PORTLAND MAINE

February 2, 2005

Re: Permit for Second means of egress 264 Stevens Ave.

### TREAD/RISER DETAIL

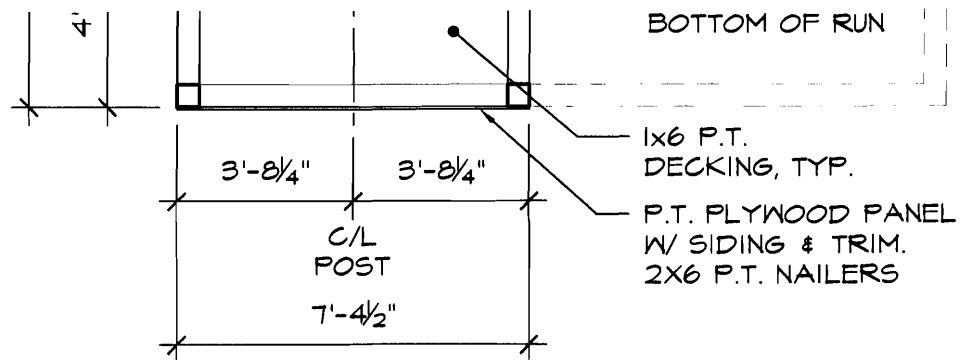
- 1) There treads and riser at 8 inches would exceed the limitations of the building code for an exterior stair. As I stated in our meeting, if there is space to comply on the lot, the code would not allow a "fire escape". I believe I gave you a copy of the code.
- 2) The bottom landings at 34 inches is too narrow and could not be approved.
